WEST SUSSEX COUNTY COUNCIL CONSULTATION

TO:	Arun District Council FAO: Neil Crowther
FROM:	WSCC - Highways Authority
DATE:	10 May 2021
LOCATION:	Bairds Farm Shop Ltd, Crookthorn Lane, Climping, BN17 5SN
SUBJECT:	CM/16/21/PL Convert existing on site storage to picnic area with fast food Cafe. This application may affect the setting of a Listed Building. This application is in CIL Zone 5 (Zero Rated) as other development.
DATE OF SITE VISIT:	N/A
RECOMMENDATION:	Advice
S106 CONTRIBUTION TOTAL:	N/A

Block Plan
Scale: 1:500

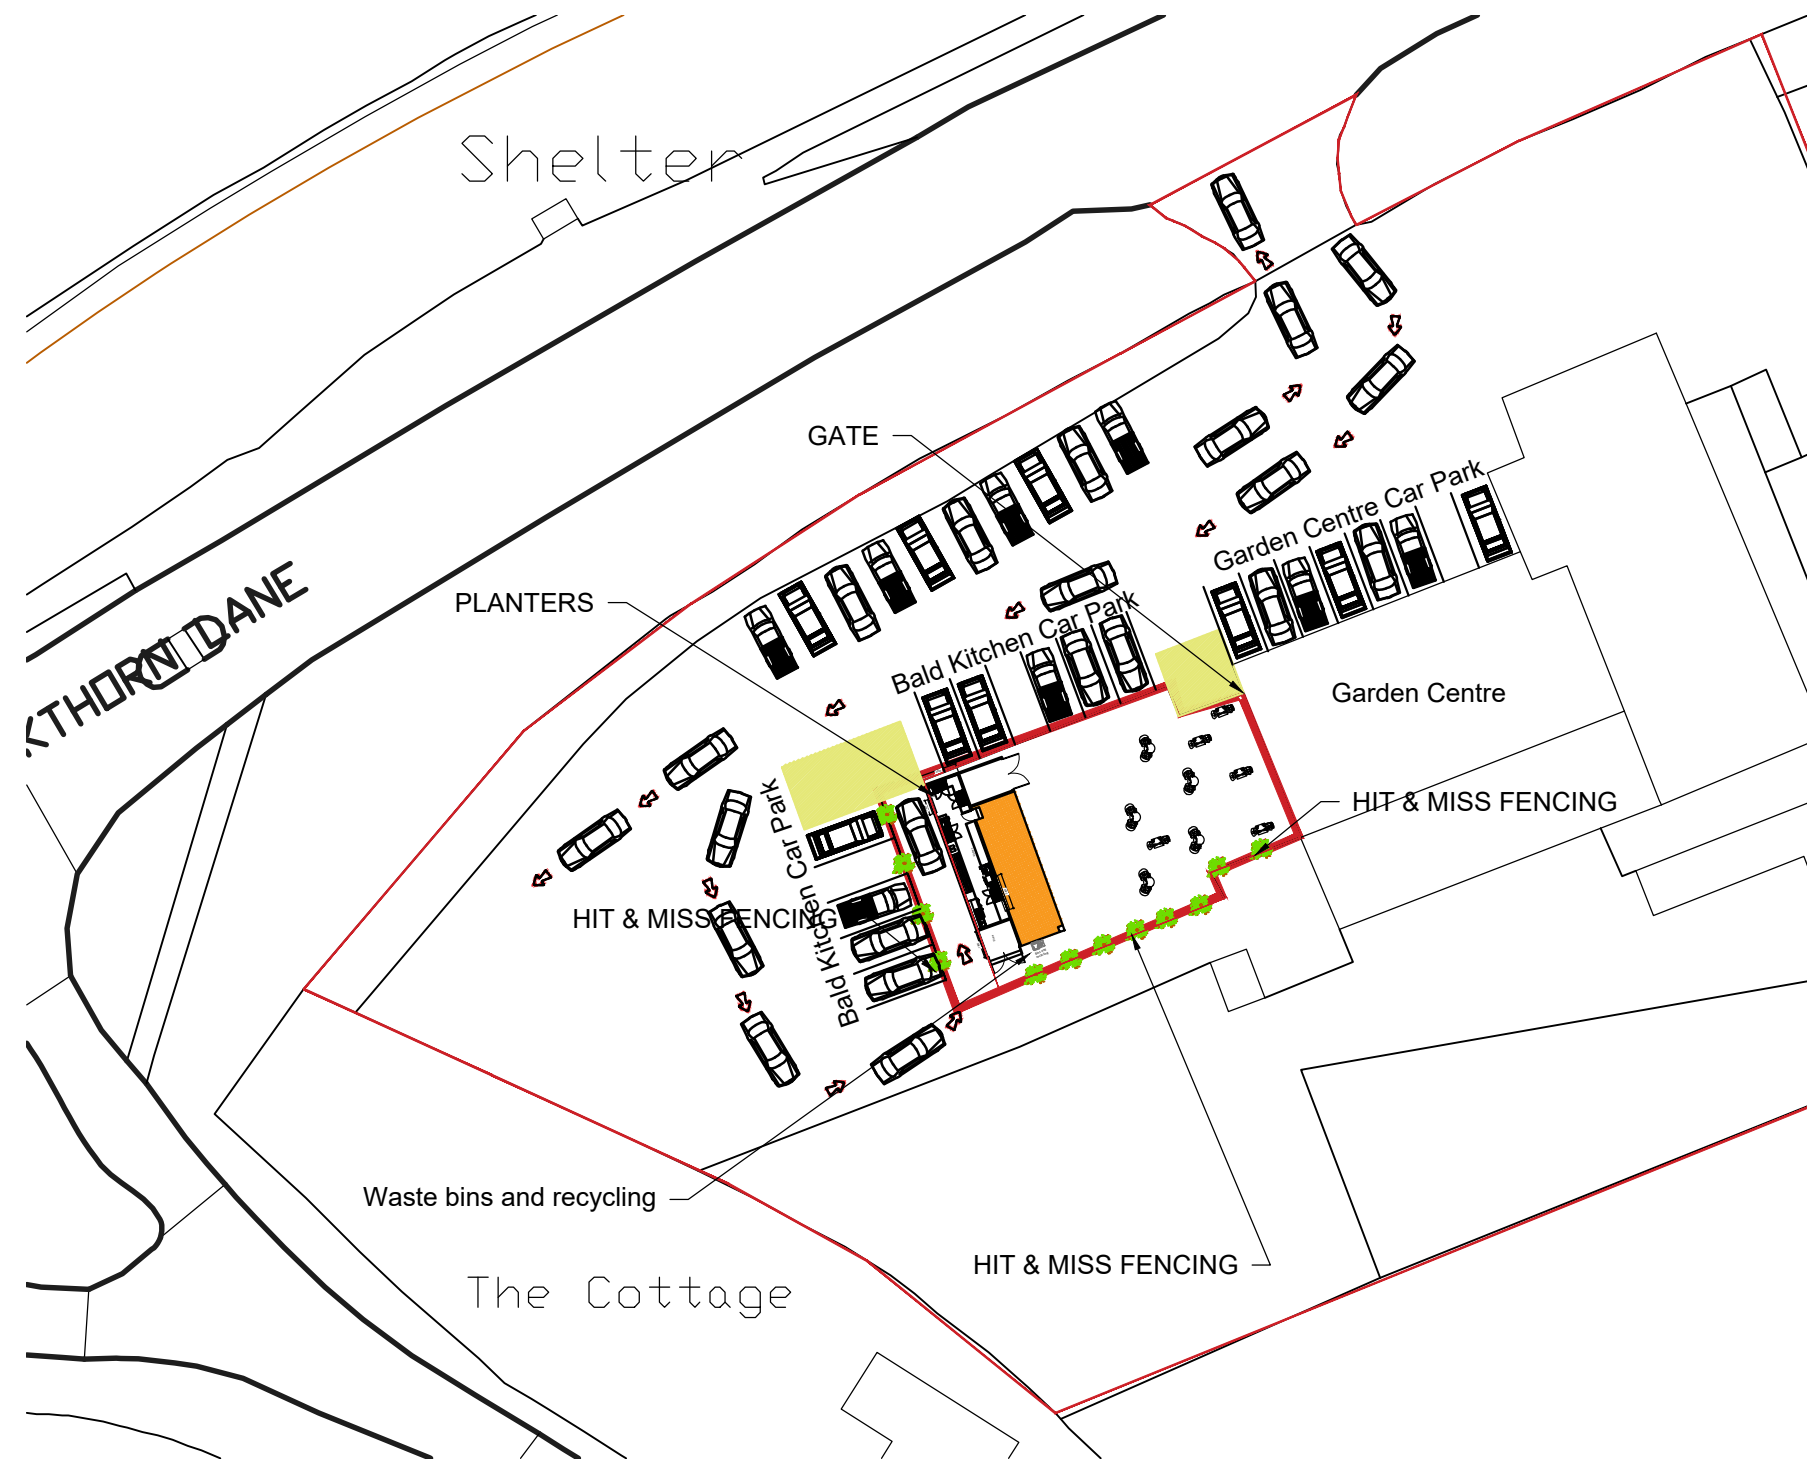
The site benefits from an existing car park with provision for approximately 65 parking spaces. The plans suggest that the proposed development will not result in the loss of any existing car parking spaces; although, clarification should be made if this is the case. The LHA anticipates that the existing car parking provision will be sufficient to accommodate those needed for the proposed development. There is also space for on-site turning to be achievable.

Nearby bus stops on Crookthorn Lane offer regular services between Littlehampton and Chichester, providing opportunities for alternative sustainable transport methods. The LHA advises the applicant to implement cycle parking provision, to further promote the use of sustainable transport methods.
